DECISION DELEGATED TO HEAD OF PLANNING

Application No: H23-0079-24 **Applicant:** Mr & Mrs M Weibel
Proposal: Erection of private stable block
Location: Copelade Lodge Little Lane Whaplode
Terminal Date: 5th July 2024

REV	DESCRIPTION	DATE
B	Site location plan amended	10.06.2024
A	Site location plan amended	01.05.2024

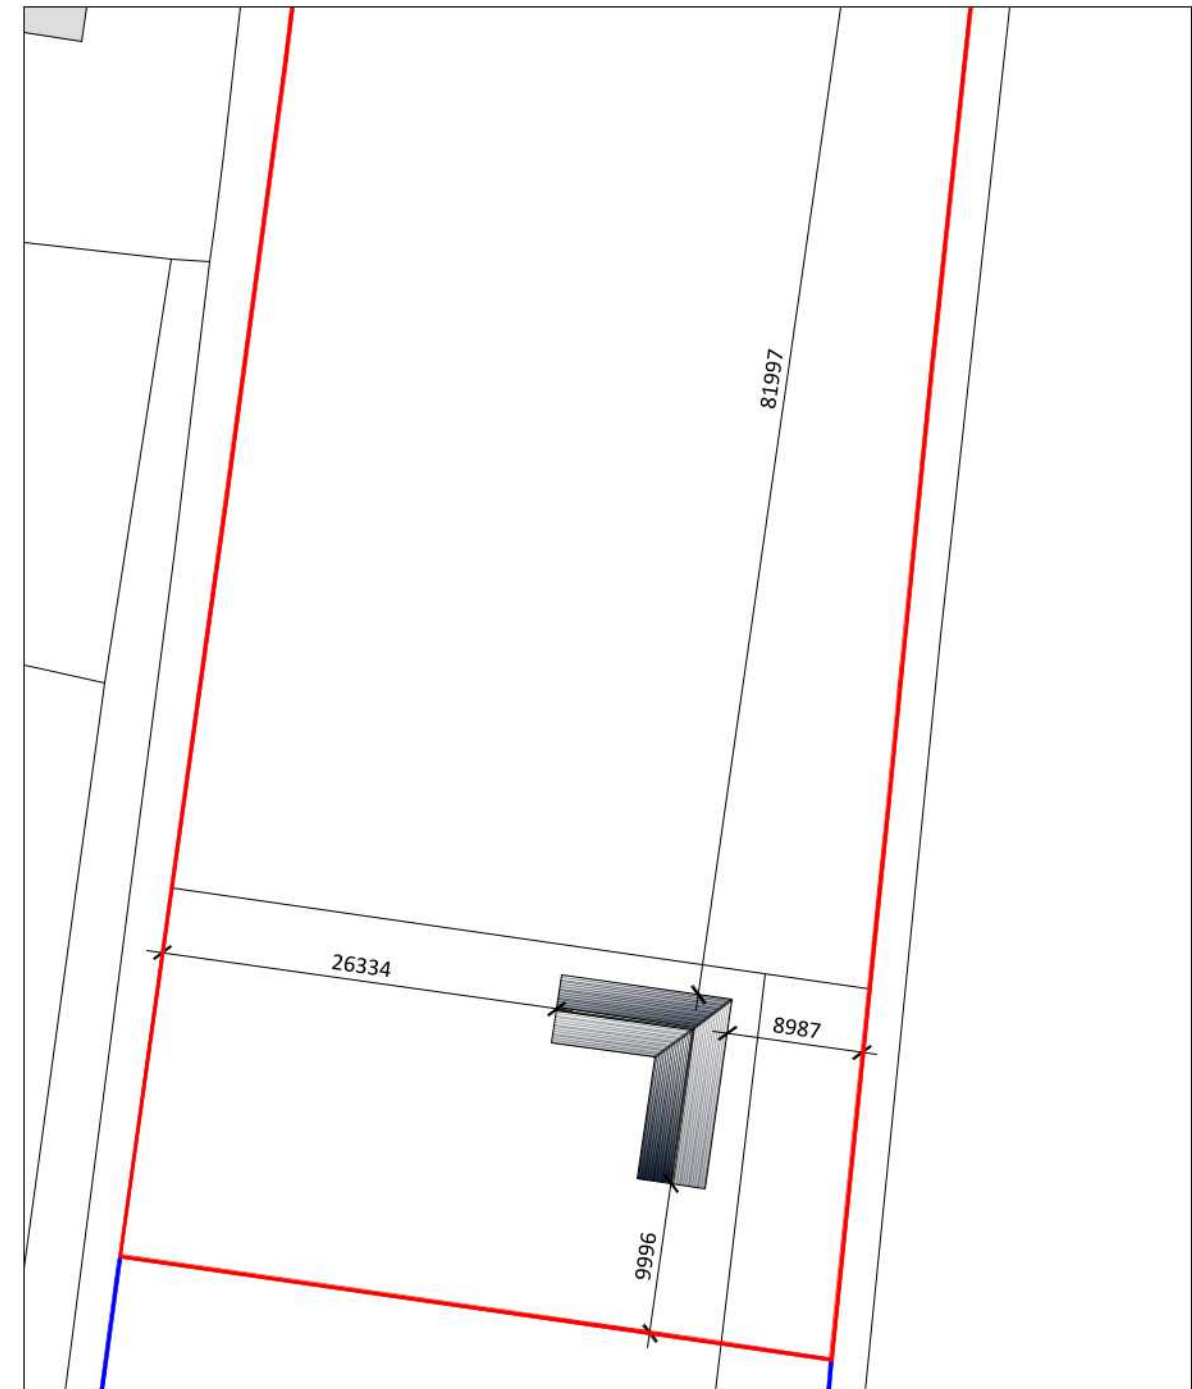
Additional information has been requested stating 'The access is grass, it needs upgrading to Lincolnshire County Council specification and a note should be added to the proposed site plan. Will the proposal lead to an increase in vehicle movements?'. Following correspondence between the Agent and Highways, a new comment has been submitted and is as follow:

Initial concern was raised by Lincolnshire County Council and led them to request additional information following the initial consultation process. They stated that 'The access is grass, it needs upgrading to Lincolnshire County Council specification and a note should be added to the proposed site plan. Will the proposal lead to an increase in vehicle movements?'. The agent later confirmed that the access track to the side of the stable block is gravel and not grass and there will be no additional vehicle movements as 'the stables are for private use by the occupants of the dwelling and will remain as such so there will be nobody travelling to or from the site as a result of the stables'. As a result of this, Lincolnshire County Council's new comments stated that 'The proposal is for the erection of a private stable block, the existing access is in a bad state of repair and in order to remove the hazard of loose material being dragged onto the public highway it will need to be upgraded to Lincolnshire County Council Specification as per the approved block plan. The proposal will not have an adverse impact on the public highway'.

Amended plans were needed outline a dividing boundary between the existing domestic land and the proposed new equestrian land. On 0432/24/01B the blue area indicates the domestic curtilage which has a total area of 4954sqm and the red boundary is equestrian which has an area of 4809sqm, this shows there is still more domestic land than equestrian paddock. The total loss of domestic land is around 25m which in comparison the land as a whole is insignificant and unsubstantial, therefore the layout is considered to be acceptable in this regard. Furthermore the land will end from an existing post and rail fence which is to be retained as a separation, this is also considered to be acceptable and is able to set a clear boundary whilst also meaning the two sets of land should not overlap.

The proposal is for the erection of a private stable block, the existing access is in a bad state of repair and in order to remove the hazard of loose material being dragged onto the public highway it will need to be upgraded to Lincolnshire County Council Specification as per the approved block plan. The proposal will not have an adverse impact on the public highway. As Lead Local Flood Authority, Lincolnshire County Council is required to provide a statutory planning consultation response with regard to drainage and surface water flood risk on all Major applications. This application is classified as a Minor Application and it is therefore the duty of the Local Planning Authority to consider the surface water flood risk and drainage proposals for this planning application.

LAYOUT PLAN (SCALE 1/100)

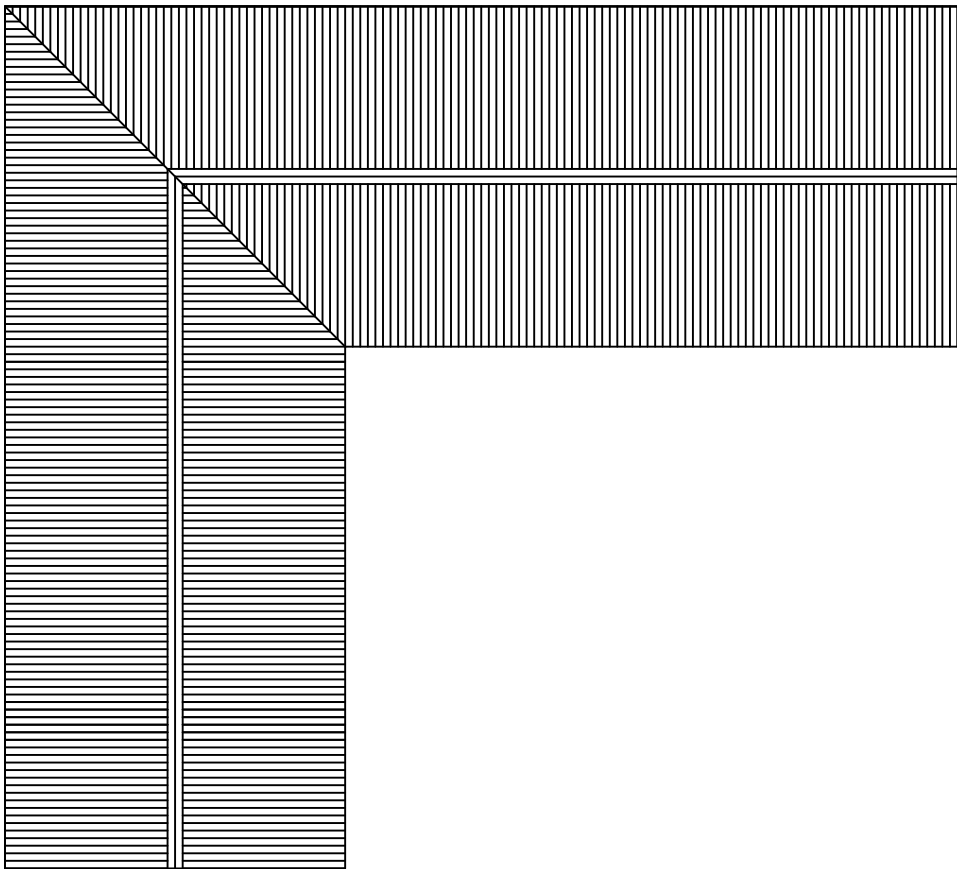
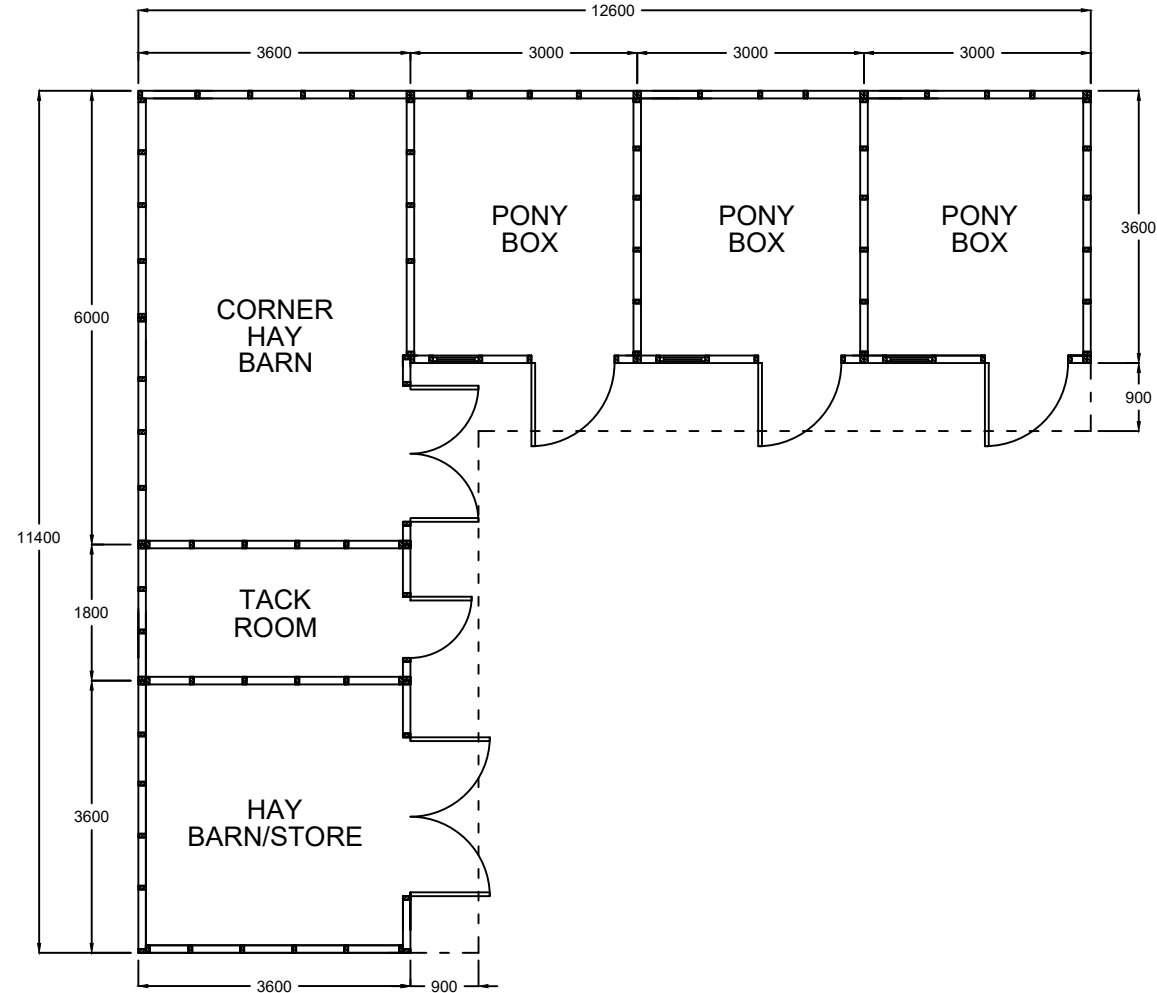
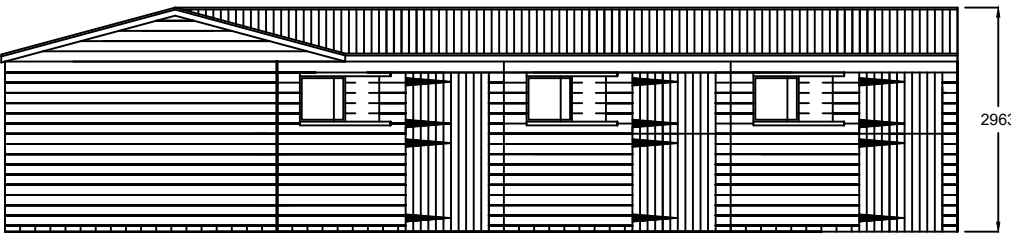
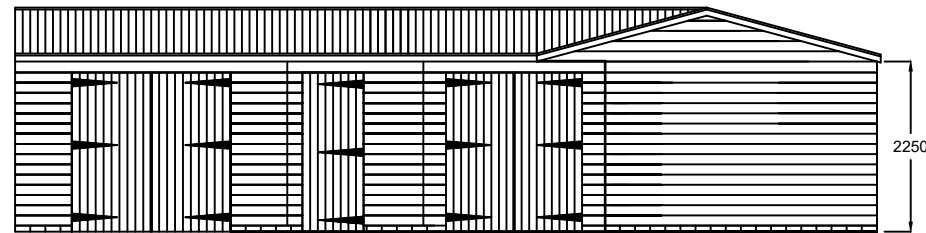
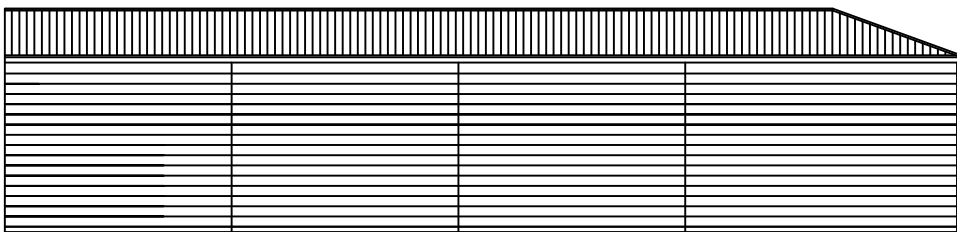
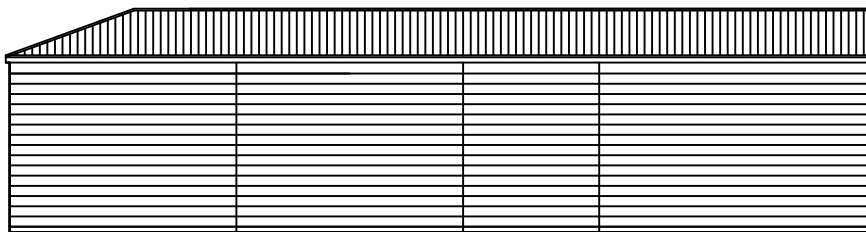
The walls of the proposed private stable block will be a timber frame and cladding using stable doors and sliding windows across the elevations. The roof shall feature a black onduline roofing with galvanised ridge on smartply boarding. Whilst the materials would not particularly match the host dwelling, this is of traditional materials used for stables such as this, furthermore, it is over 116m from the highway and should not cause any material harm to the street scene or locality in this regard.

On the northern elevation the length will be around 11400mm with the eastern length being slightly more at around 12600mm. The widths on both the west and south are 3600mm, to the eaves the stable shall be 2250mm and have a total height of 2963mm; the gable roof will have a slight overhang of around 900mm. These measurements are considered to be acceptable as the stable provides a modest area to operate within with an internal floor space of approximately 68.5 metres squared.

Internally, the barn is split into six separate rooms/ areas. Along the rear there is a large corner hay barn (6000mm by 3600mm), a track room (1800mm by 3600mm) and another hay barn/ store adjacent to this (3600mm by 3600mm). Furthermore, along the eastern side there are three pony box of the same size but are all split (3600mm by 3000mm). As mentioned above, the size of the stable allows it to appear proportionate and these measurements for each room are also acceptable for the residents to operate within the development.
